**Kent
Police**

Direct Line: 01622 653234
E-mail: pandcr@kent.police.uk
Date: 14th November 2019
Ref: 19/05000/HYB/AF1

Application Ref: 19/05000/HYB
Location: DSTL Fort Halstead Crow Drive Halstead Sevenoaks
KENT TN14 7BU

Proposal: Hybrid application comprising, in outline: development of business space (use classes B1a/b/c) of up to 27,659 sq m GEA; works within the X enclave relating to energetic testing operations, including fencing, access, car parking; development of up to 750 residential dwellings; development of a mixed use village centre (use classes A1/A3/A4/A5/B1a/D1/D2); primary school; change of use of Fort Area and bunkers to Historic Interpretation Centre (use class D1) with workshop space and; associated landscaping, works and infrastructure. In detail: demolition of existing buildings; change of use and works including extension and associated alterations to buildings Q13 and Q14 including landscaping and public realm, and primary and secondary accesses to the site.

VIEW: BLOCK B

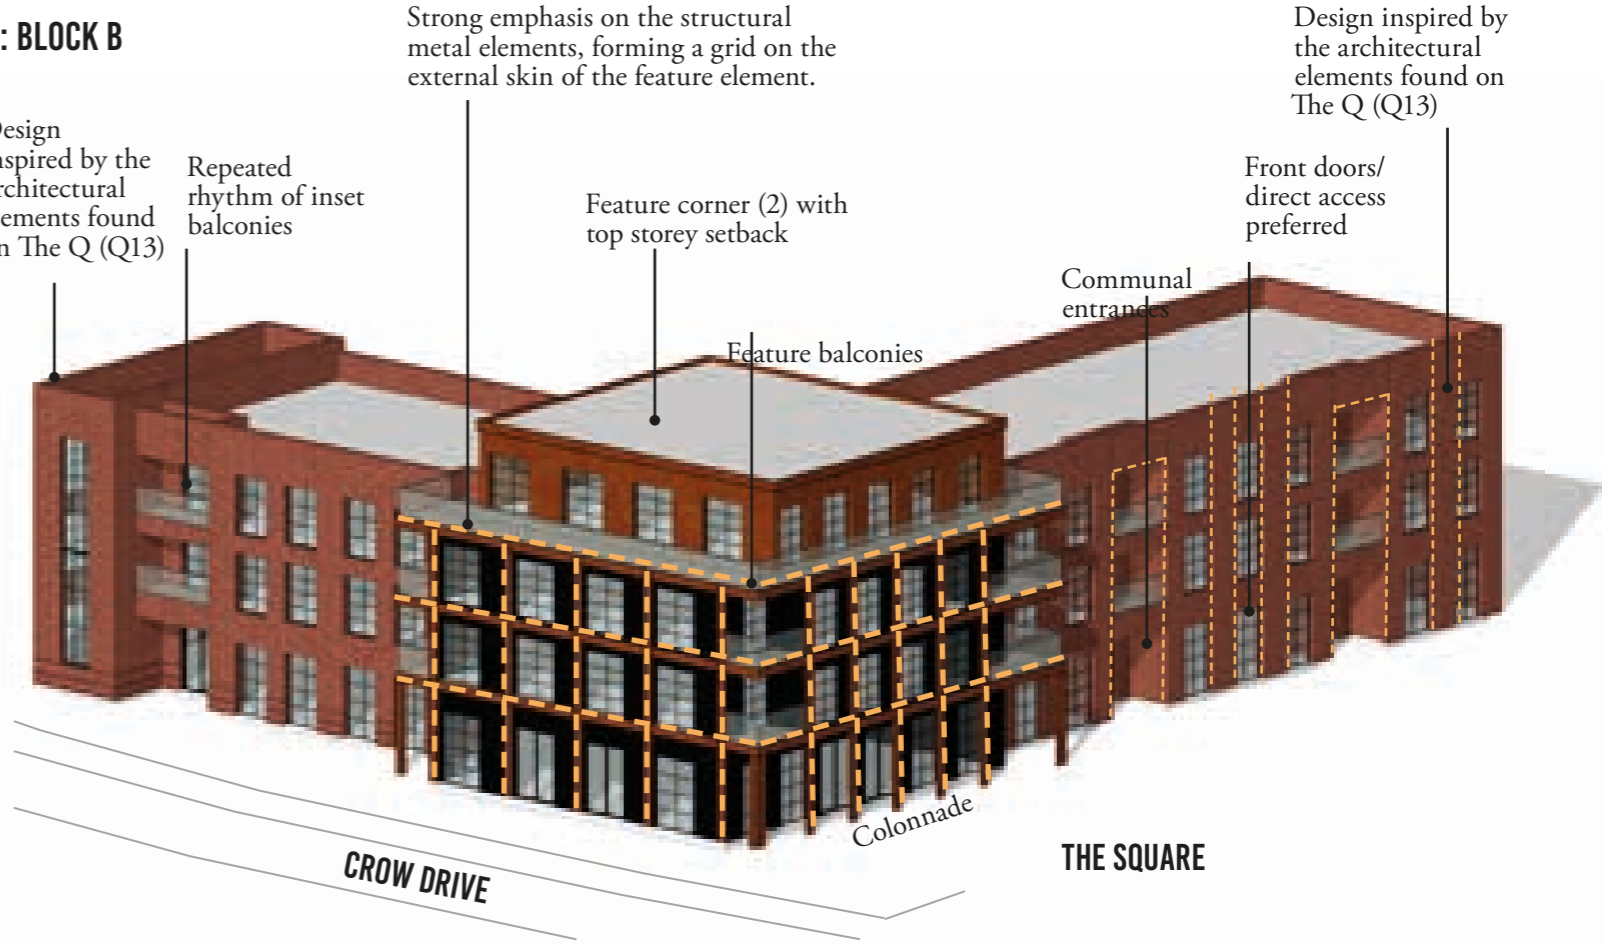
5. Corner Properties and defensible spaces.
6. Recesses. We note the inclusion of recesses as part of the building design of the proposed Blocks (e.g. Block B). These recesses give us some cause for concern as they may provide hiding areas and opportunities to commit crime.
